**DECISION DELEGATED TO HEAD OF PLANNING**

**Application No:** H09-1278-25                      **Applicant:** Loosegate Developments Ltd

**Proposal:** Proposed Erection of 2 Bungalows

**Location:** Land East Of Forest Way Holbeach Spalding

DRAWING NUMBER | LDC4657 - 11

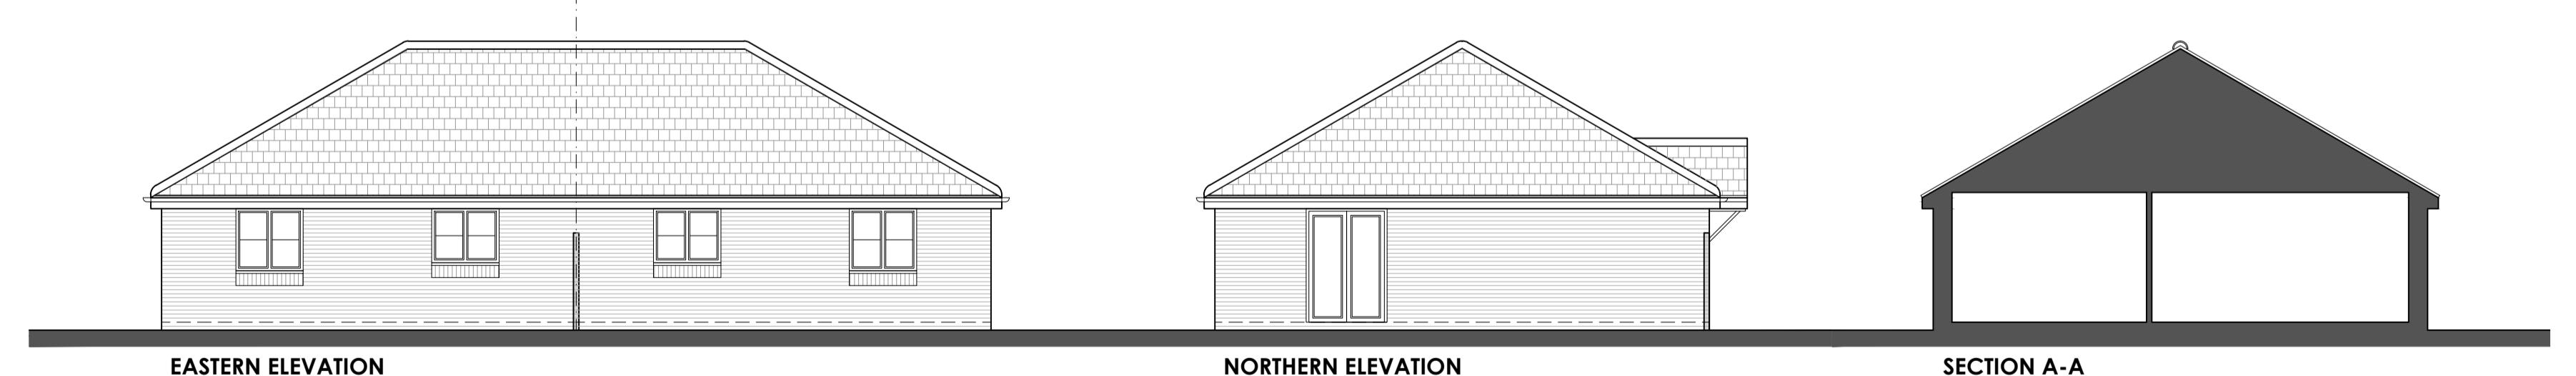
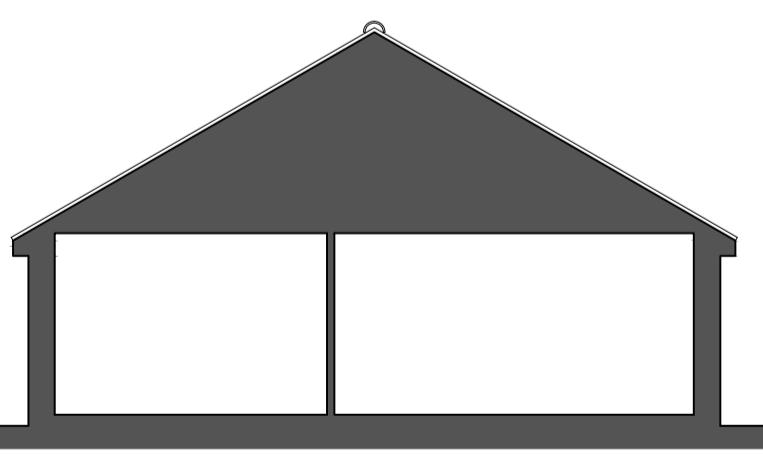
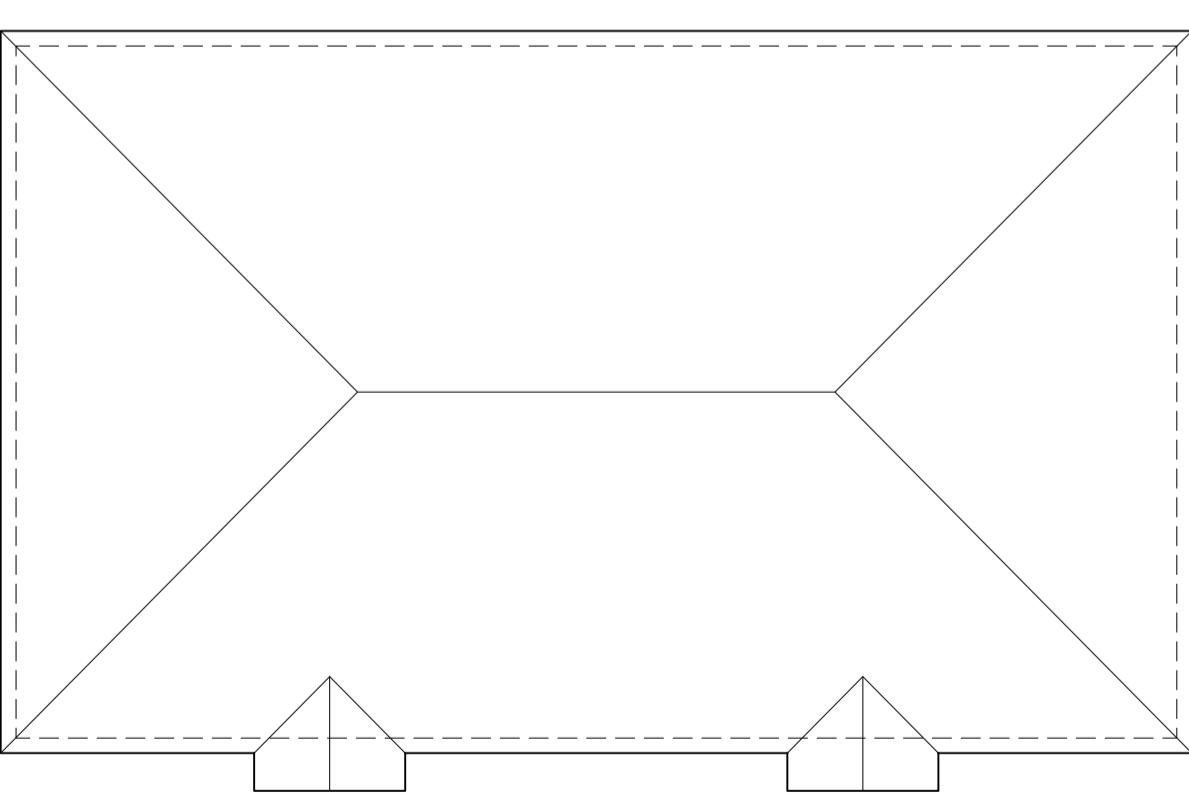
The bungalows are proposed to be semi-detached, featuring a hipped roof form and two porch roofs

on the front roof slopes. The bungalows feature symmetrical facades. The ridgeline height of the bungalows measures 5.3m and the eaves measure 2.5m in height. Although the proposed materials are not yet confirmed, the plans show brick soldier course detailing beneath the windows on the bungalows.

The bungalows are proposed to be located to the east of Forest Way, facing to the road. Two parking spaces are proposed for each of the bungalow next to Forest Way. Side gardens are proposed to the north and south of the bungalows and some planting is shown indicatively within the front garden areas. The 3D visualisation of the site shown on the 'Proposed Bungalows' plan (LDC4657-11) shows mature trees next to the site. As set out above, this is misleading as the developer has not provided trees as previously proposed.
